THE GRANARY  
CAULK LANE  
SWAITHE  
BARNSELY  
S70 3QG

**Proposed Stabling**

14/10/08

THE GRANARY AND PADDOCK, SWAITHE HALL HAMLET. FEB. '03.
 SCALE. 1.500.

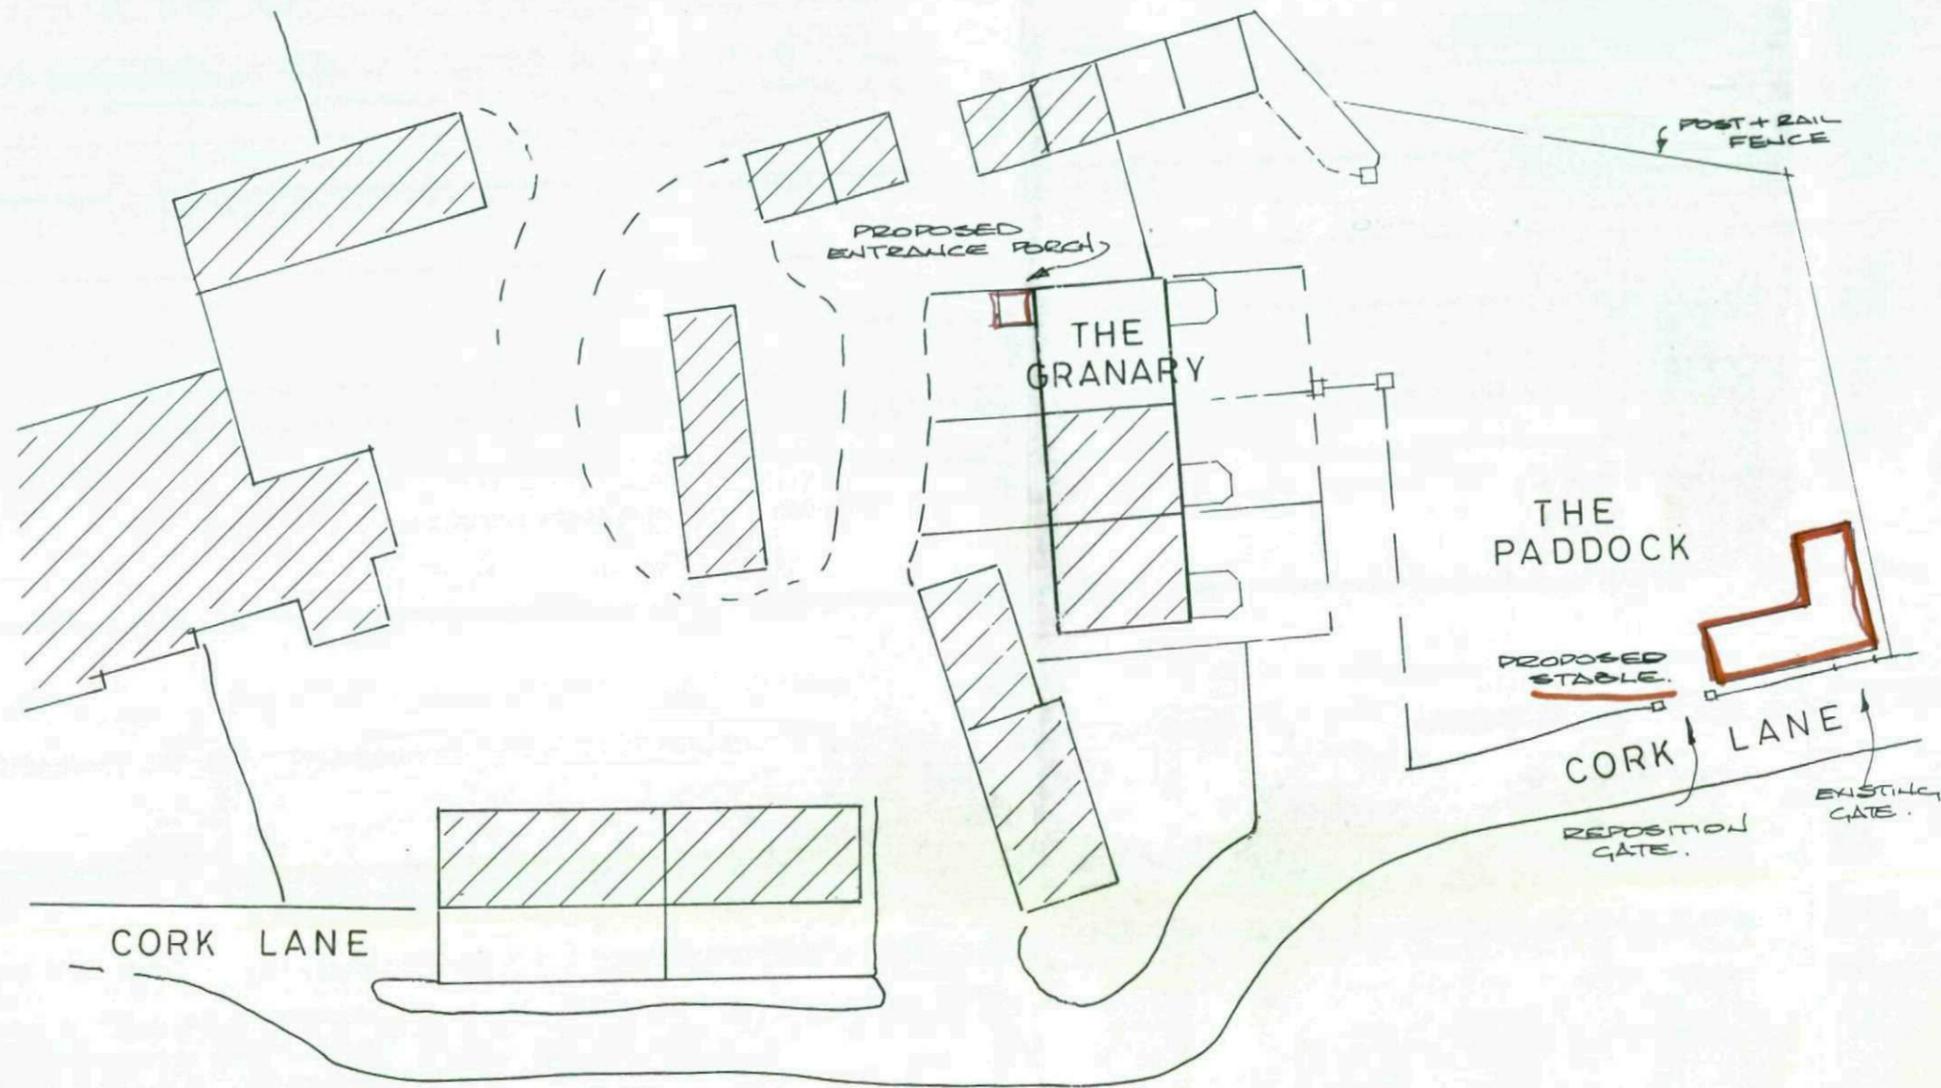
**Question(4)** – The paddock is enclosed by rail and fence all the way around except as you say a length of about 30ft, this is at the rear of the dwelling?

**Answer(4)** – The fence will continue all the way around the perimeter, not to have a space where there is no fence missing, totally enclosed area.
